**COMMENTS ON THE APPLICANT'S
DEADLINE 5 SUBMISSIONS**

SUGGESTED DRAFT S.106 AGREEMENT

DEADLINE 6

**A63 Castle Street Improvement Scheme
HULL
TR010016**

Figure 16: % change in maximum flood depth during a 1 in 1000-year River Hull tidal flood event (Hull Tidal Surge Barrier open)

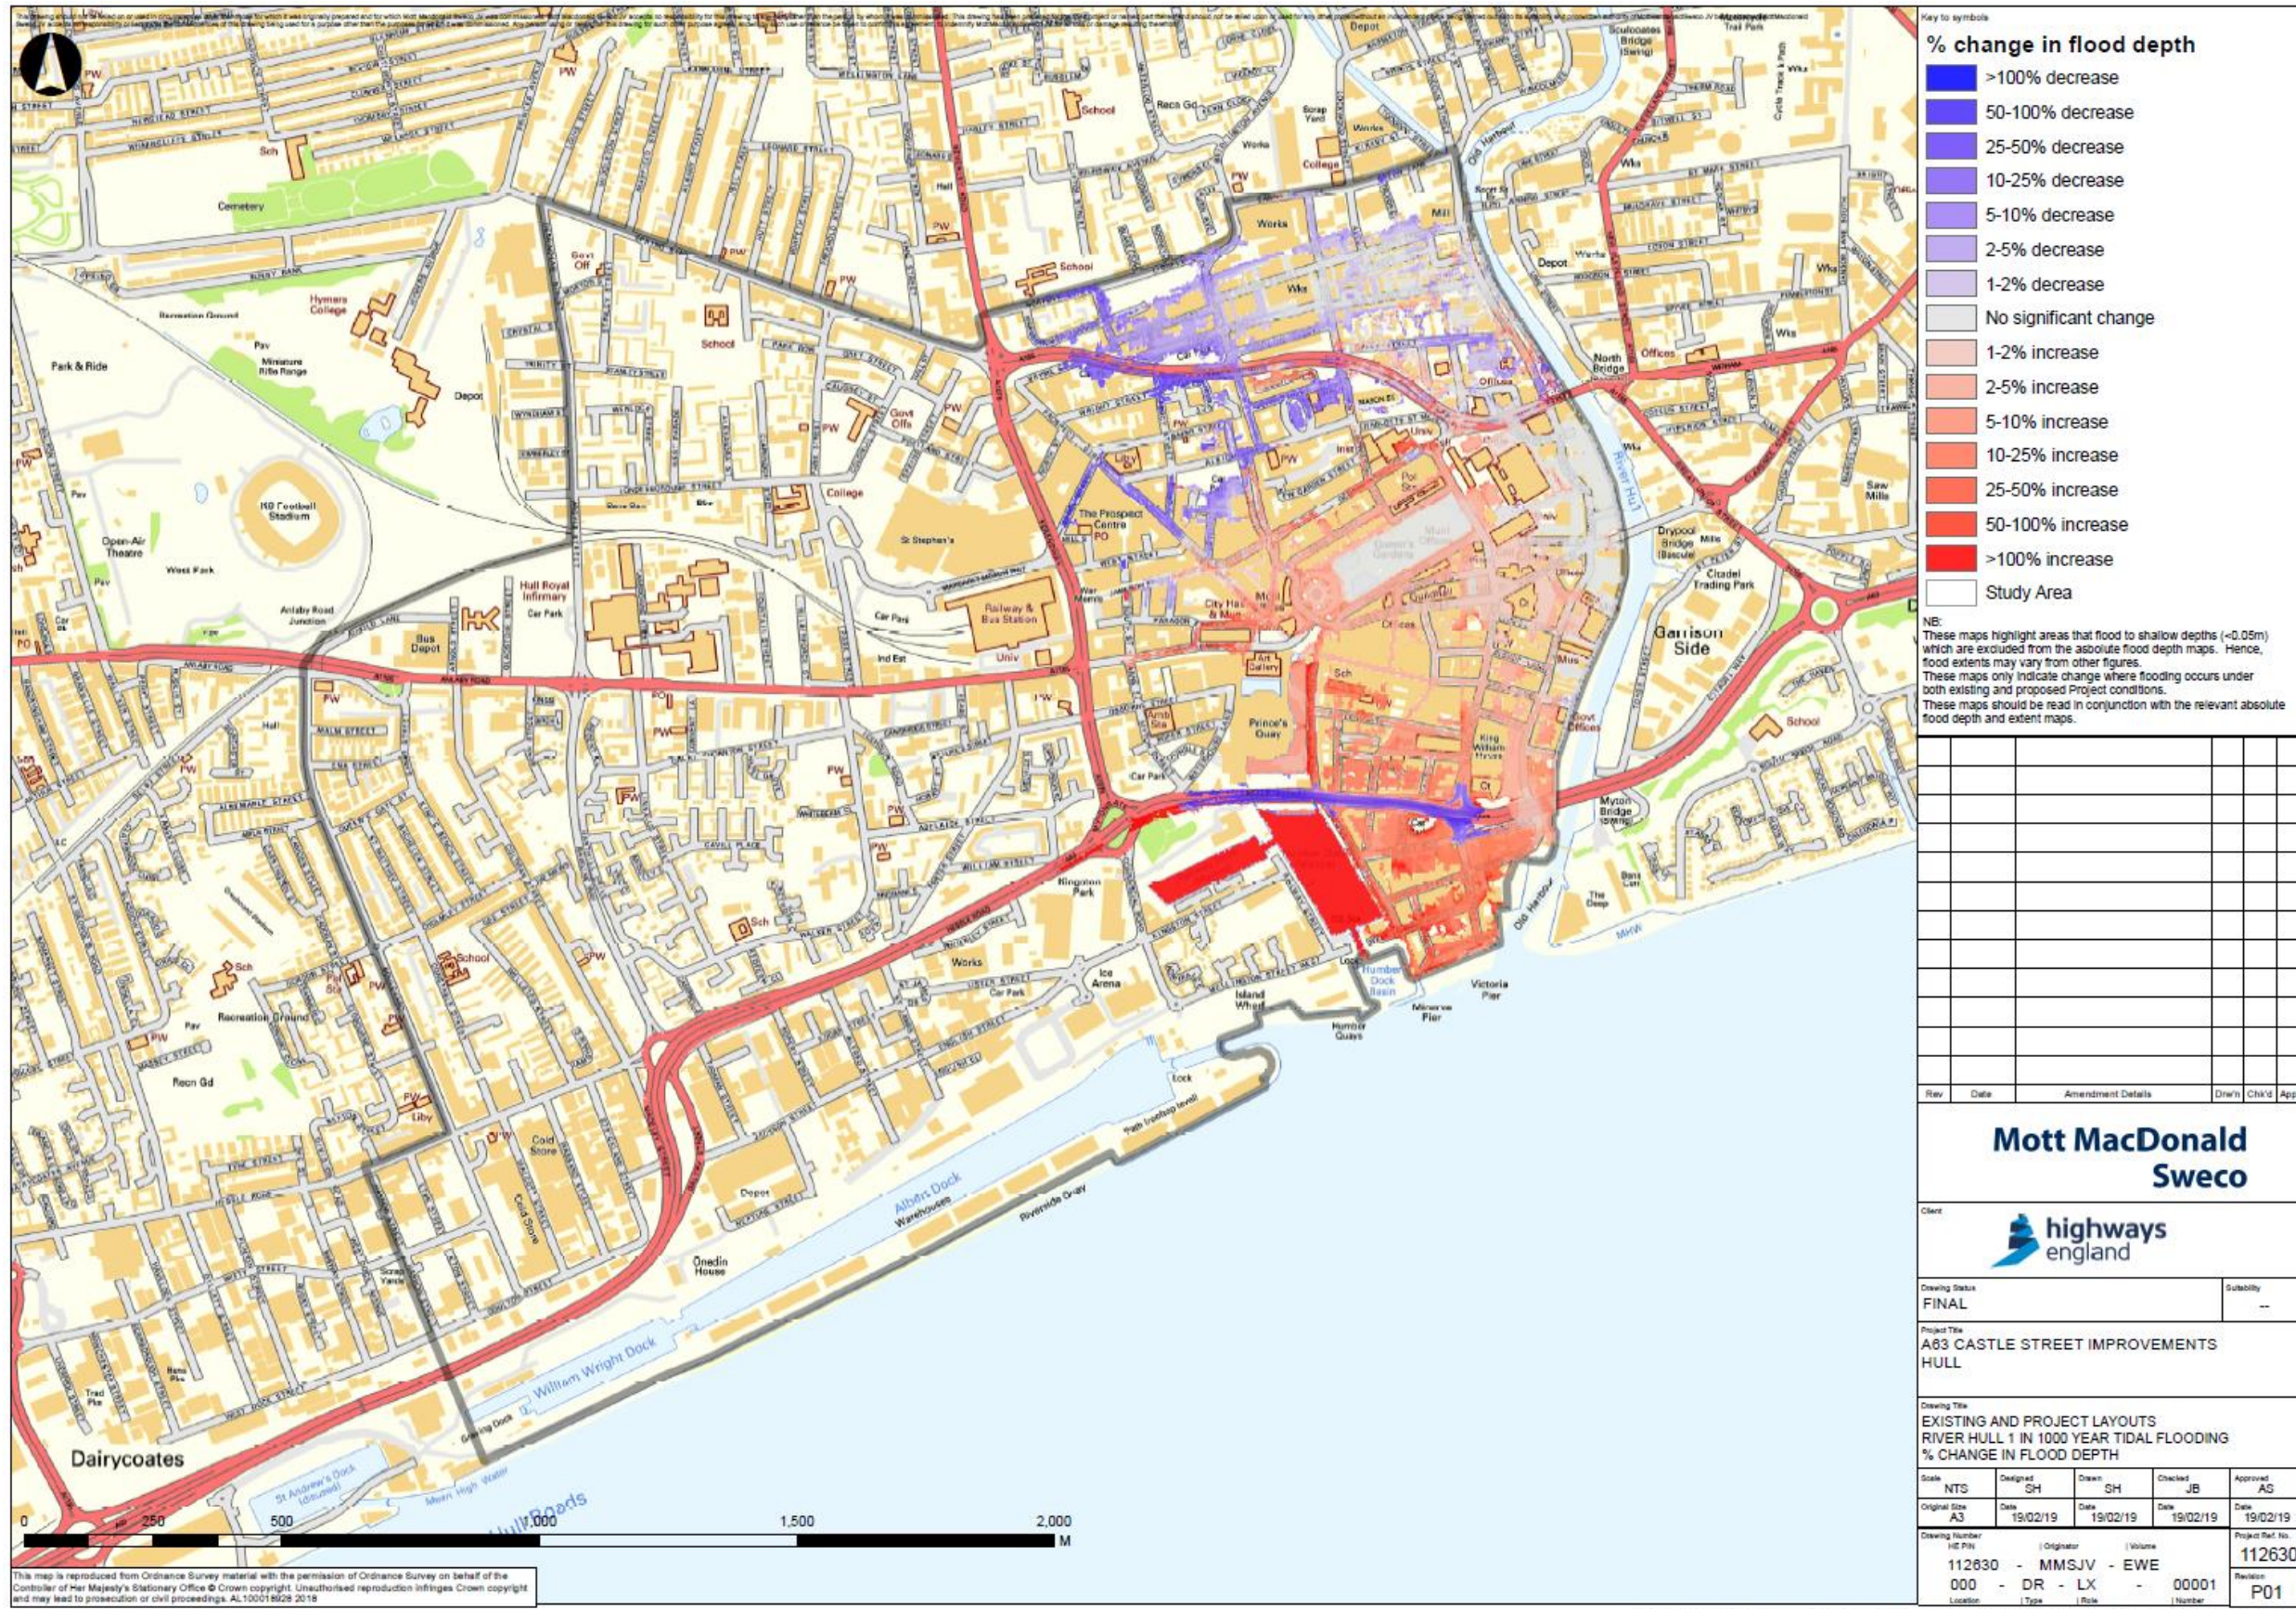
HCC welcomes the submission of the updated Flood Risk Assessment and related Technical Note. It is noted that the revised document makes specific reference to the proposed presence of a Vertical Concrete Barrier along the centre of the Trunk Road, and models the effect of the same under various scenarios. The ExA will be aware of recent and on-going discussions over the design of the central barrier.

HCC recognises the utility of a central reserve barrier, but in general terms would be supportive of minimising the height of any barrier in flood risk terms. This is because the barrier, in certain scenarios, can prevent flood water from being relieved by the full capacity of highway drainage infrastructure.

HCC also consider that the effect of the Vertical Concrete Barrier, whilst of limited material impact relative to predicted depths under the different scenarios modelled, would be less desirable than that of a barrier with solid elements of lower height, given that this would serve to reduce depths to the south of the A63, where impacts are predicted to be more significant.
